### **RAS EXHIBITION HALLS REDEVELOPMENT**

Thank you for providing the drawings prepared by Ancher Mortlock Woolley (AMW), indicating alternative approaches to the stage 1 design.

Drawing Title
NORTH ELEVATION

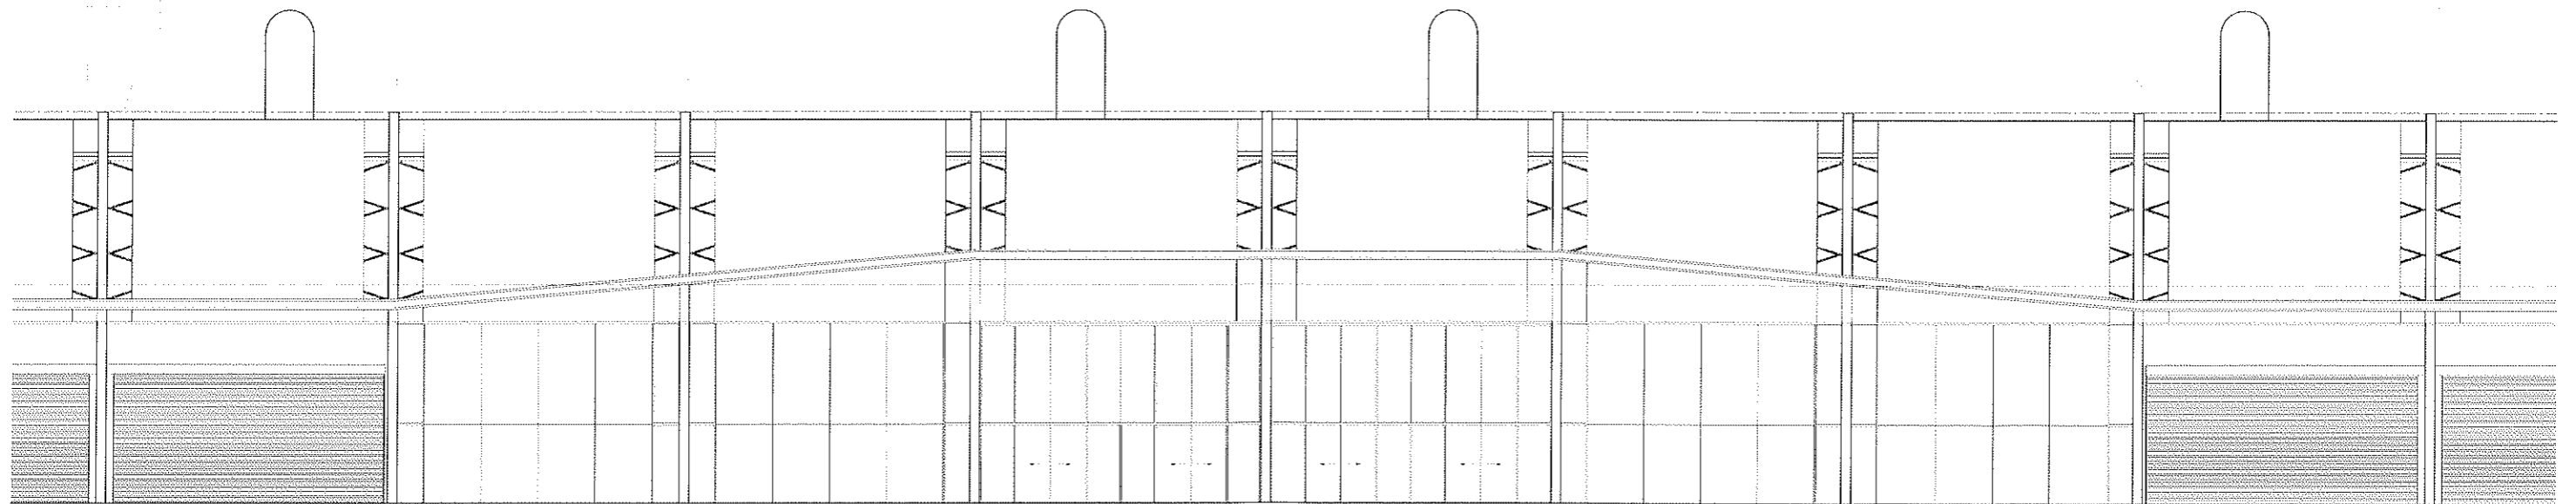
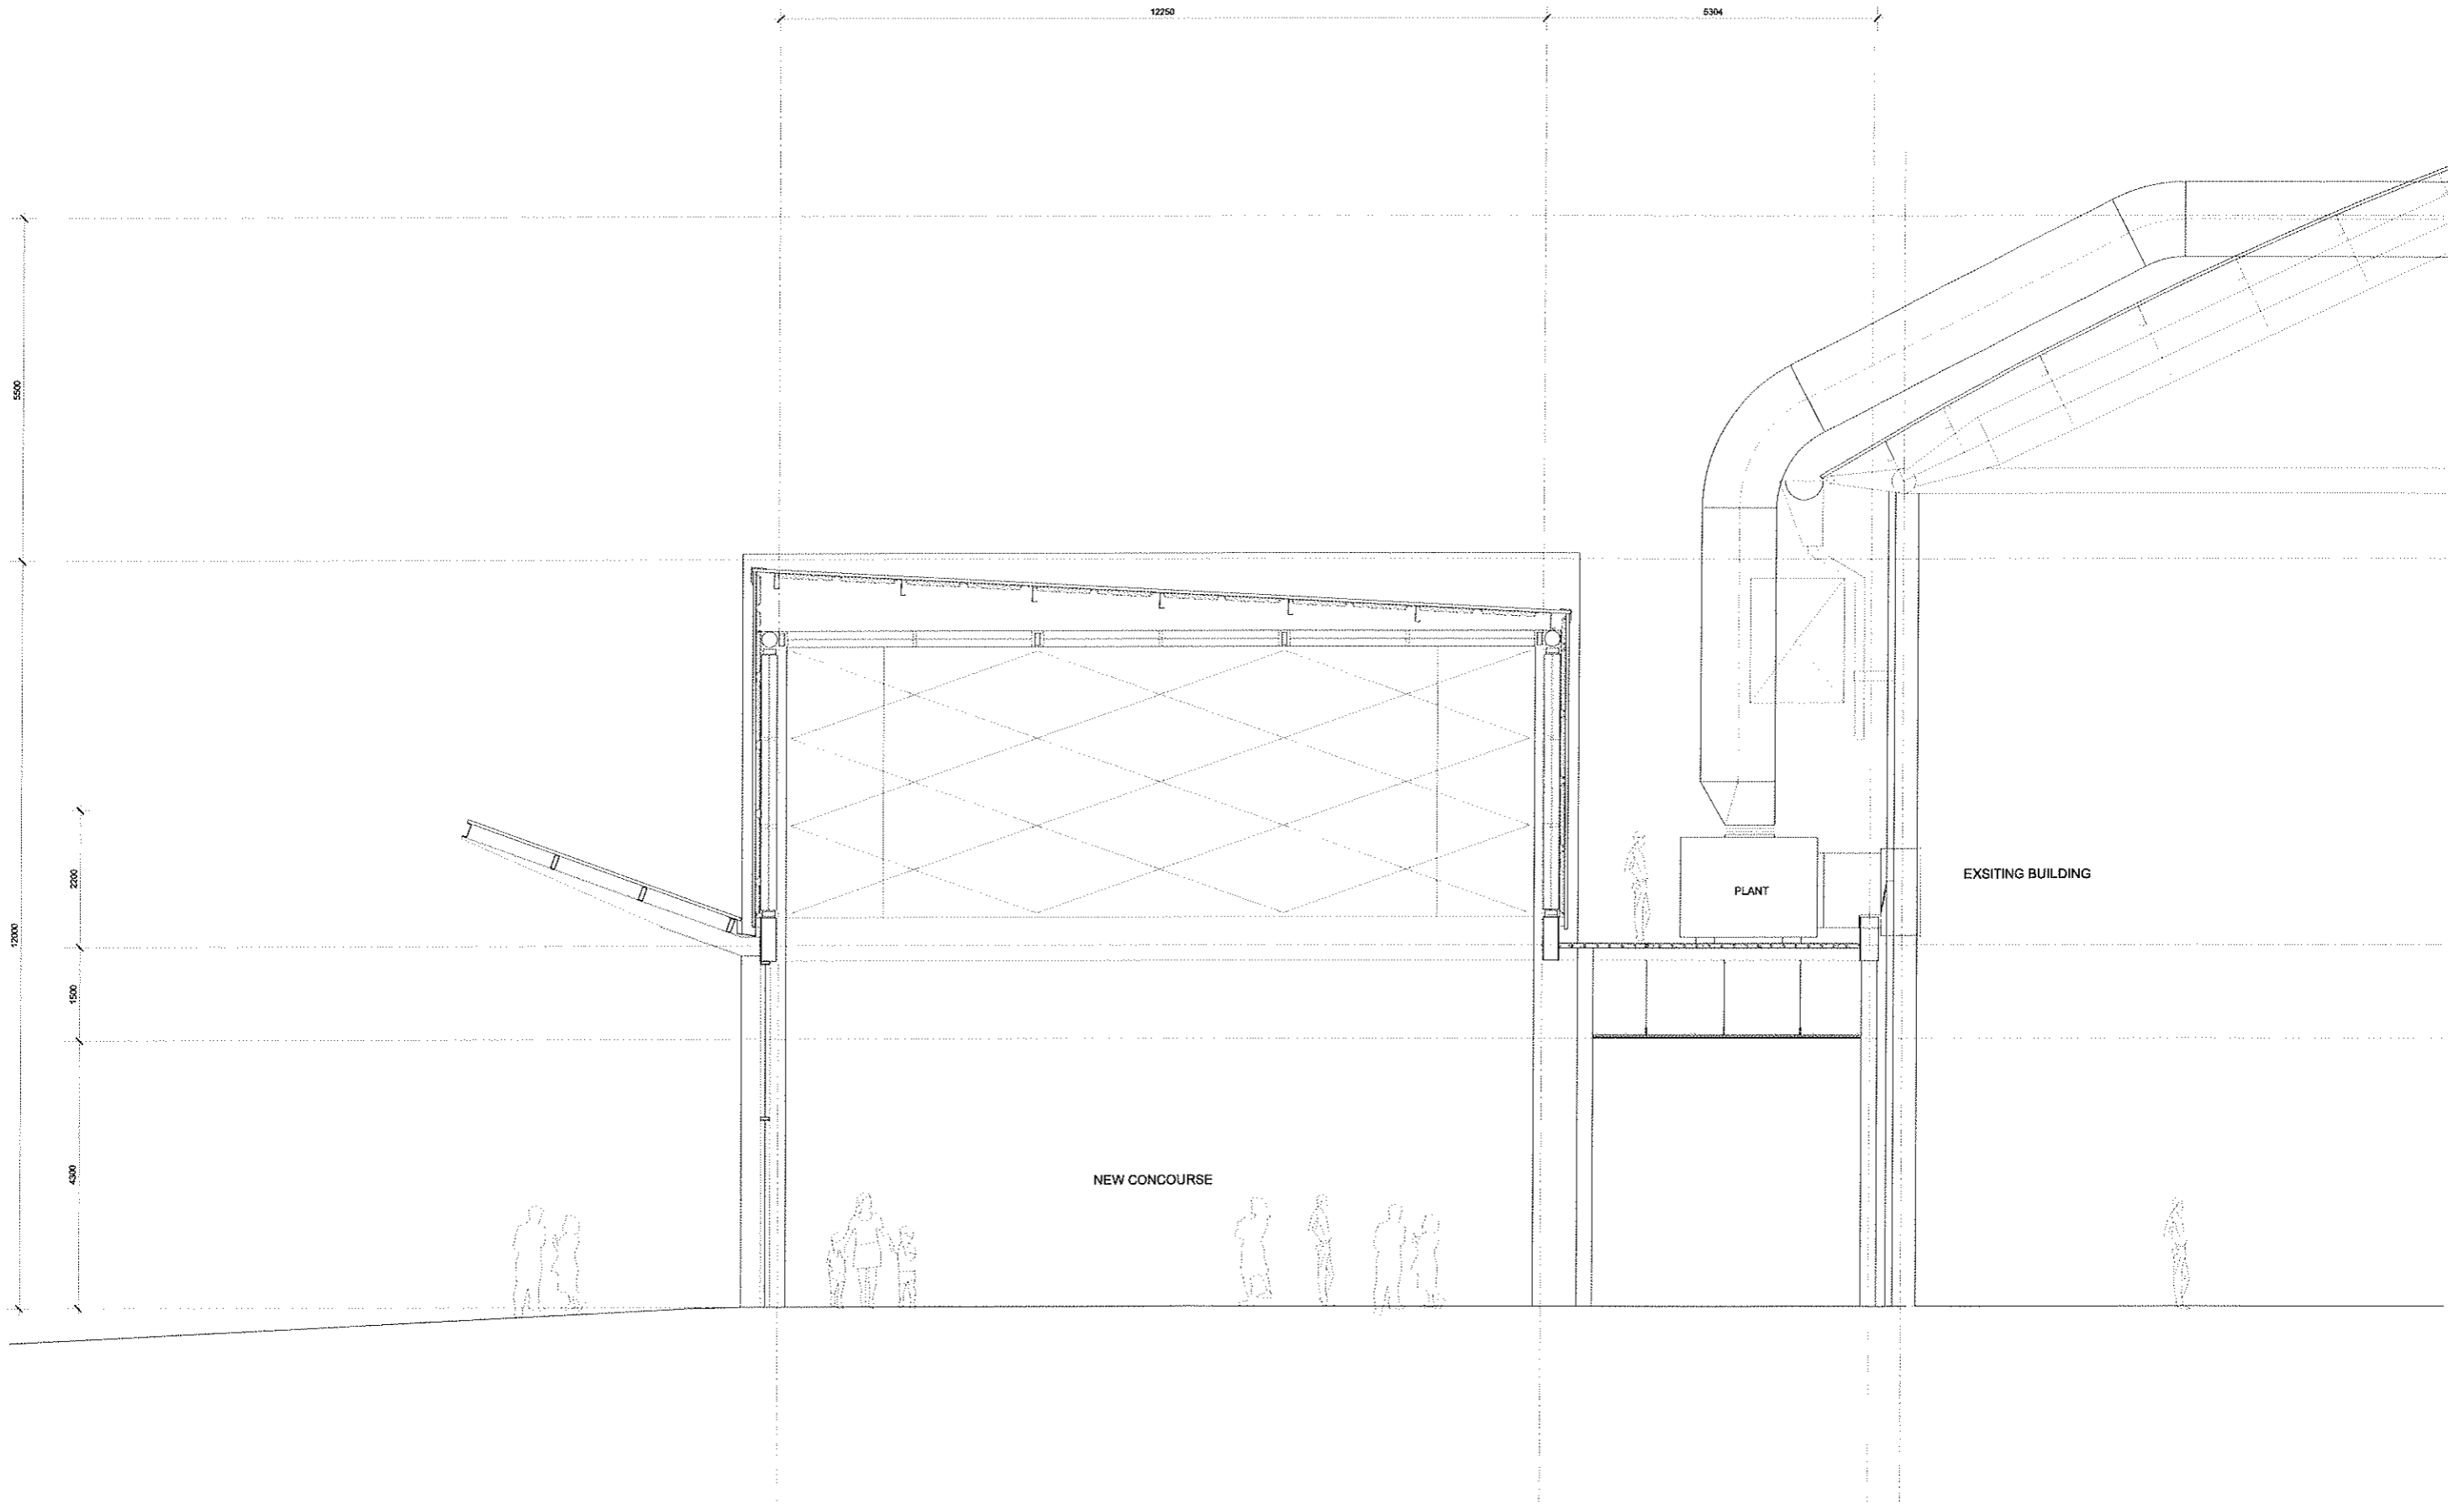
1. The concourse roof proposal cleverly adapts the language of the existing exhibition halls into a lively and expressive northern frontage for the exhibition halls. While the height is low enough to provide some external glimpses of the existing Hall roofs, it precludes the opportunity for future upper level seminar rooms which were originally proposed in the Cox design. Considering the longer term objectives of the RAS expansion, where the concourse area will be contained by exhibition halls on both sides, the simple 'linear' form currently proposed provides a more neutral edge to the distinctive profile of the existing exhibition halls and is a more suitable approach for both the short and long term redevelopment of the facility.

2. Following on from DRP comments, the current 'linear' design should be reviewed in relation to external finishes and the internal 'diagrid' structure. Literal references to the original design elements should be avoided.
